EPC STORMWATER REVIEW COMMENTS ARE SHOWN IN ORANGE BOXES WITH BLACK TEXT

STORMWATER MANAGEMENT PLAN (SWMP)

THE SITE IS LOCATED AT 12050 FALCON HIGHWAY, FALCON, CO 80831, AND AT APPROXIMATELY 38°55'36.21"N LATITUDE, 104°36'10.29"W LONGITUDE. THE PROPOSED PROJECT CONSISTS OF DEMOLITION OF THE EXISTING RUNNING AND BASEBALL TRACKS, PARKING LOT ADJUSTMENTS, UTILITY SERVICE CONNECTIONS, OVERLOT GRADING, BUILDING CONSTRUCTION, STORMWATER INFRASTRUCTURE CONSTRUCTION, PAVING OF ADA PARKING LOTS, ENTRANCE DRIVES, AND UTILITY INFRASTRUCTURE CONSTRUCTION IN THE TOWN OF FALCON, CO. THE TOTAL SITE AREA IS APPROXIMATELY 30.42 ACRES. NO AREAS GREATER THAN 40 ACRES SHALL BE DISTURBED AT ANY GIVEN TIME. NO CONSTRUCTION ACTIVITIES SHALL OCCUR OFFSITE OR OUTSIDE OF THE CONSTRUCTION LIMITS SHOWN ON THE CONSTRUCTION DOCUMENTS. THE SEQUENCE OF CONSTRUCTION STARTS IS AS FOLLOWS:

SHEET TITLE  
INITIAL  
EROSION  
CONTROL PLAN  
A

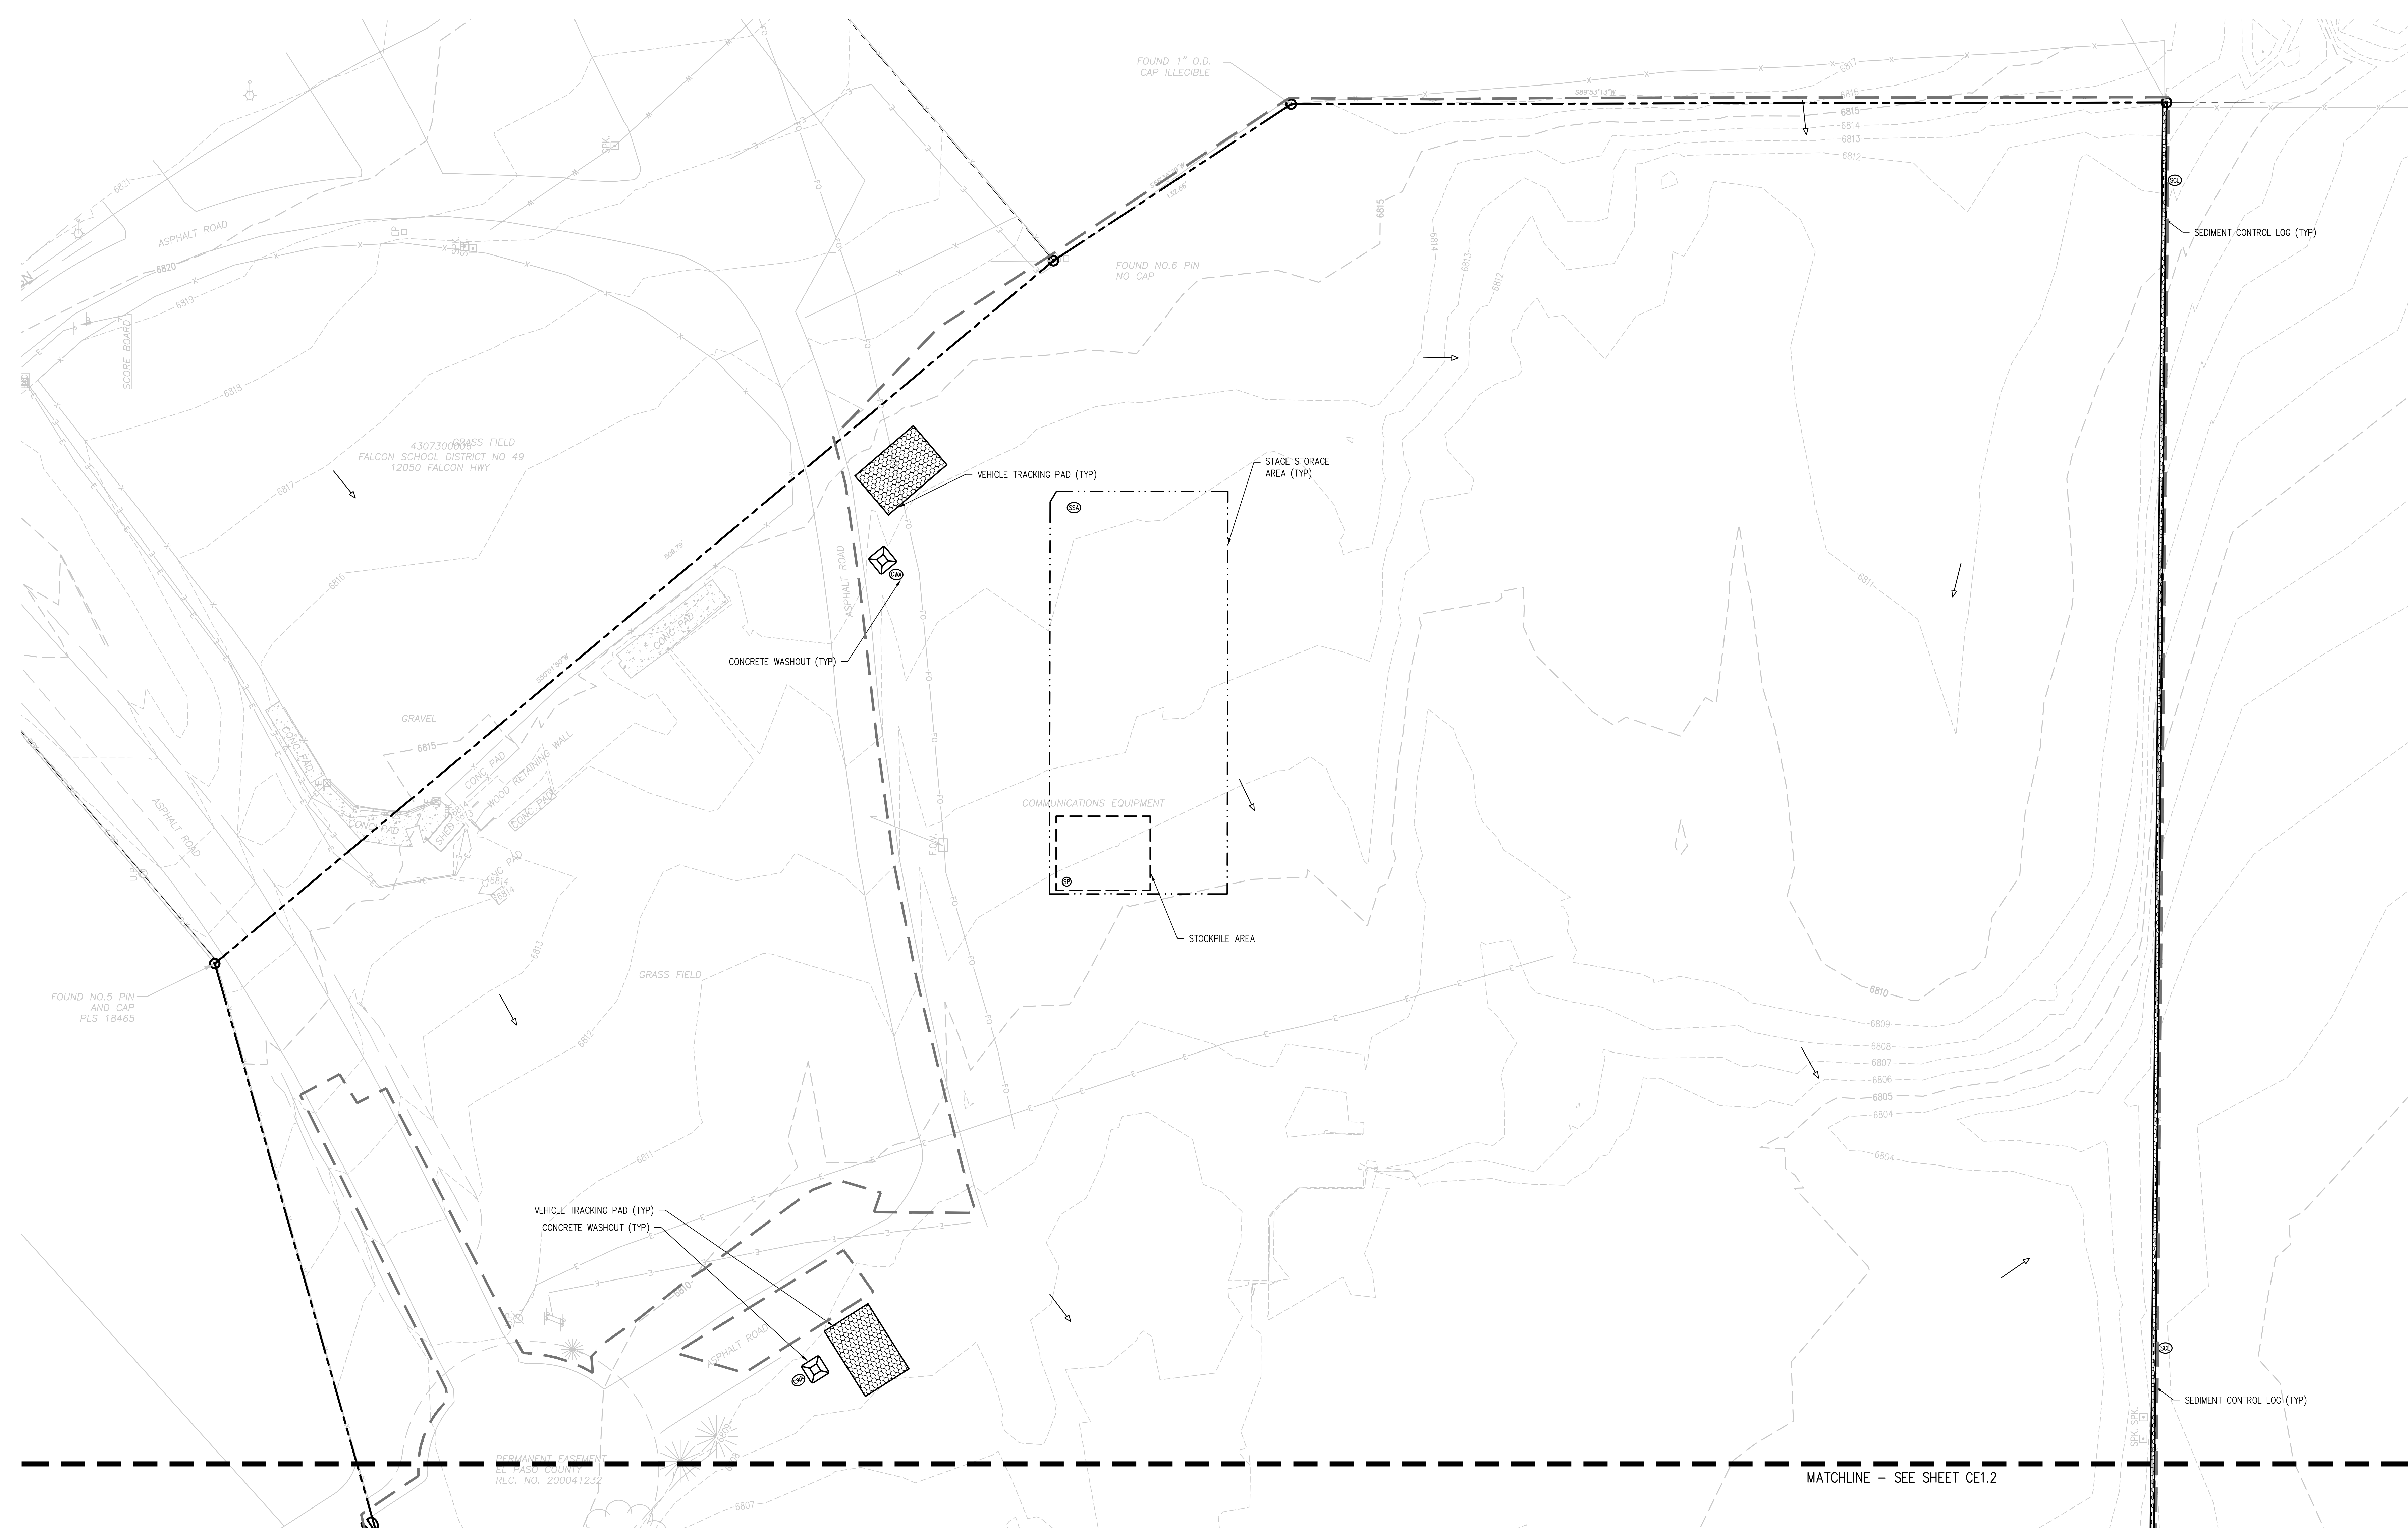
Item 9. Please include method for determining ground cover (i.e., visual, aerial inspection)

Item 10. Potential pollution sources are associated with proposed construction

Item 11. Please include a spill response plan and procedures. THE CONTRACTOR WILL STORE CONSTRUCTION MATERIALS AND EQUIPMENT IN CONFINED AREAS ON SITE FROM WHICH RUNOFF WILL BE CONTAINED AND FILTERED. MATERIALS WILL BE STORED OFF THE GROUND AND PROTECTED FROM THE WEATHER BY A COVER OR STORED IN A CONTAINER SUCH AS A VAN OR TRAILER. AN EARTHEN DIKE WILL BE CONSTRUCTED AROUND THE PERIMETER OF THE FUEL STORAGE AREA TO PREVENT MATERIALS FROM CONTACT WITH SURFACE RUNOFF. EQUIPMENT MAINTENANCE WILL BE PERFORMED IN A DESIGNATED AREA AND STANDARD MAINTENANCE PROCEDURES, SUCH AS THE USE OF DRIP PANS, WILL BE USED TO CONTAIN PETROLEUM PRODUCTS.
